Ref: Application Number 2020/90125

We are replying to the above planning application that has been put in for an erection of a detached dwelling adjacent to 1 The Copse, Scholes, Cleckheaton, BD19 6NE.

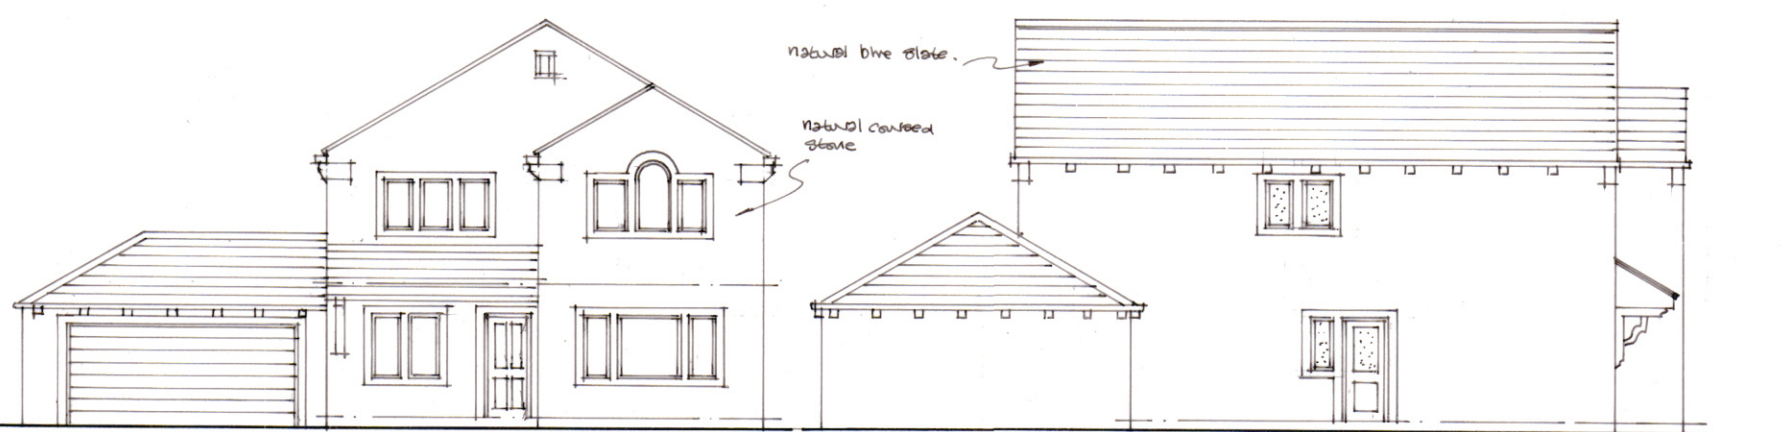
Calder Architectural Services Ltd who have facilitated the drawings and plans for the proposed development have stated that the new dwelling will be of traditional design and constructed in matching materials to those adjacent properties within the Copse. We believe this to be untrue, as all current properties within the Copse are evenly spaced and of similar L shaped design and do not have blue slate roofs. We believe the house would look very much out of place within the Copse. The National Planning Framework guidelines state that all developments should be visually attractive as a result of good architecture and layout and sympathetic to local character and the surroundings.

### Appendix 7: Arboricultural Implications Plan

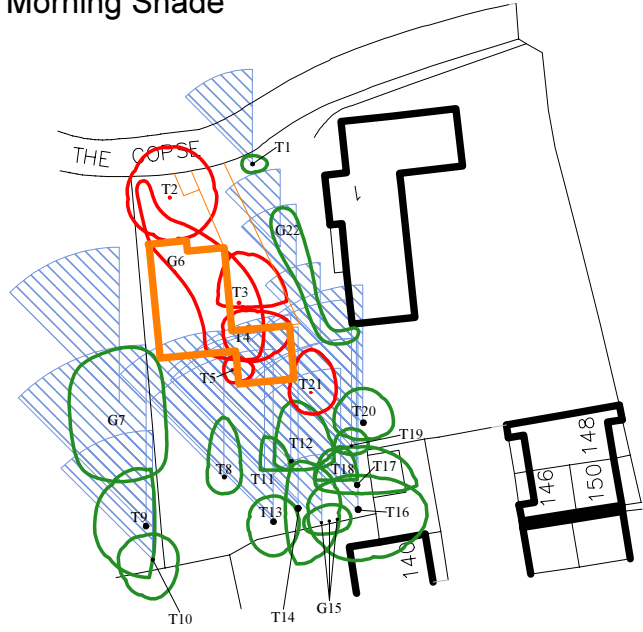
Another concern is the felling of 10 trees to facilitate the proposed plans. Before the houses in the Copse were built, the trees were already part of the landscape and the developments were positioned around them.

According to the Arboricultural Report carried out at 1 the Copse, these trees are currently seen as having a moderate impact on the local treescape. They identified 15 different species of trees, which ranged in age from semi-mature to mature. All these trees are located within the Hartshead Moor Top Conservation Area.

We believed that all the trees in the Copse had Preservation Orders on them and we are of the understanding that all trees within a conservation area have a degree of protection, as per the point 7.20 of the Arboricultural Report.
